From:
Sent: 14 March 2024 09:38
To: DCAdmin
Subject: Planning Application 2024/62/90339/E

Re: Application 2024/62/90339/E

EXISTING BLOCK PLAN
1:500

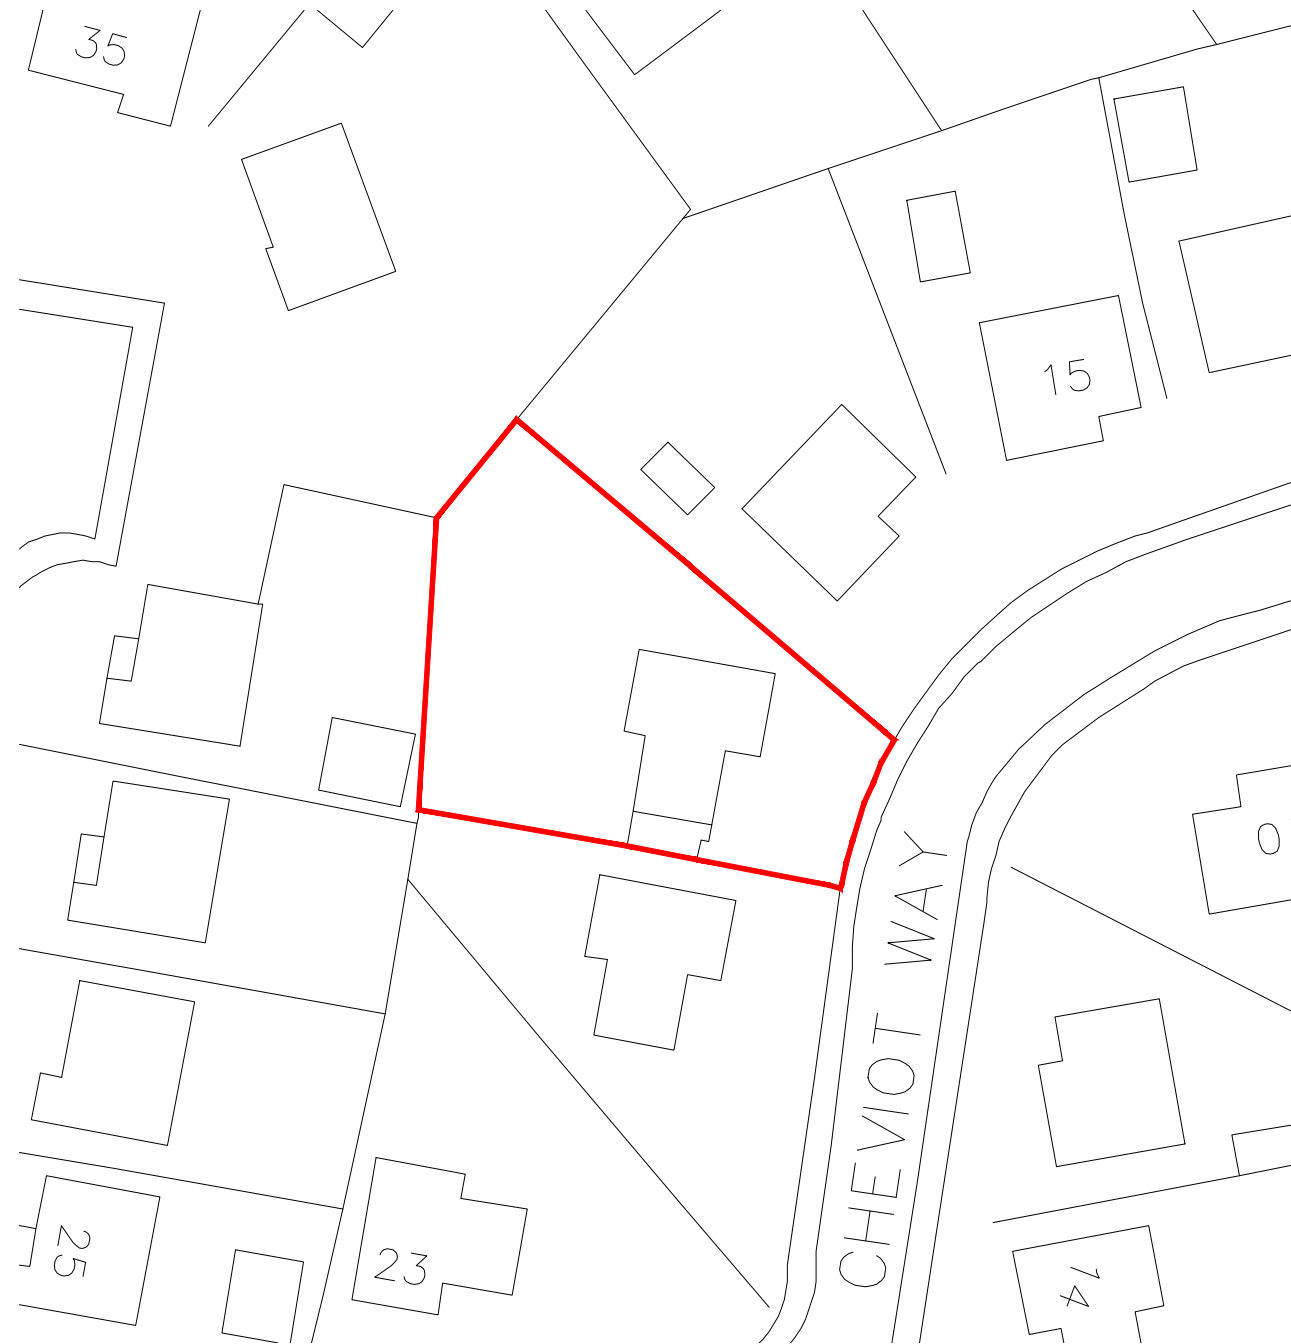
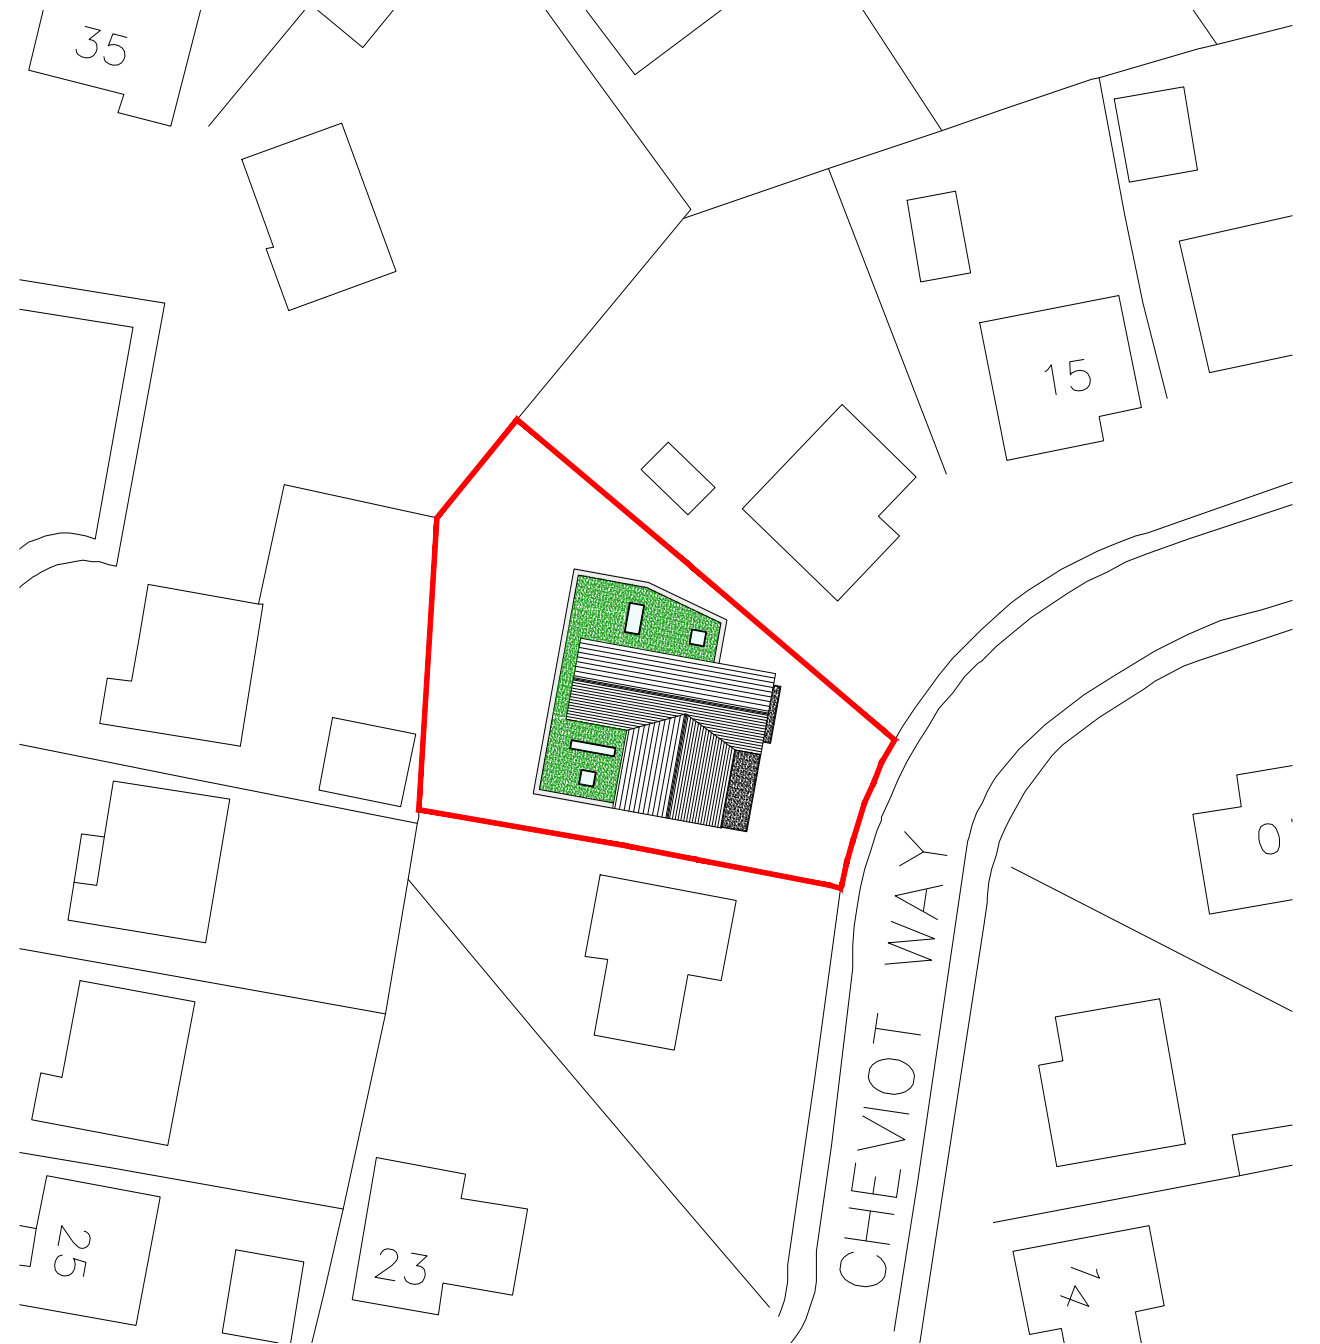
This is to inform you that the block plan submitted as part of the application is inaccurate - our property was built c.20 years ago and yet is not shown. I feel it important to raise as we are directly behind no. 19, in no. 33a, yet on the plans submitted our house doesn't exist.
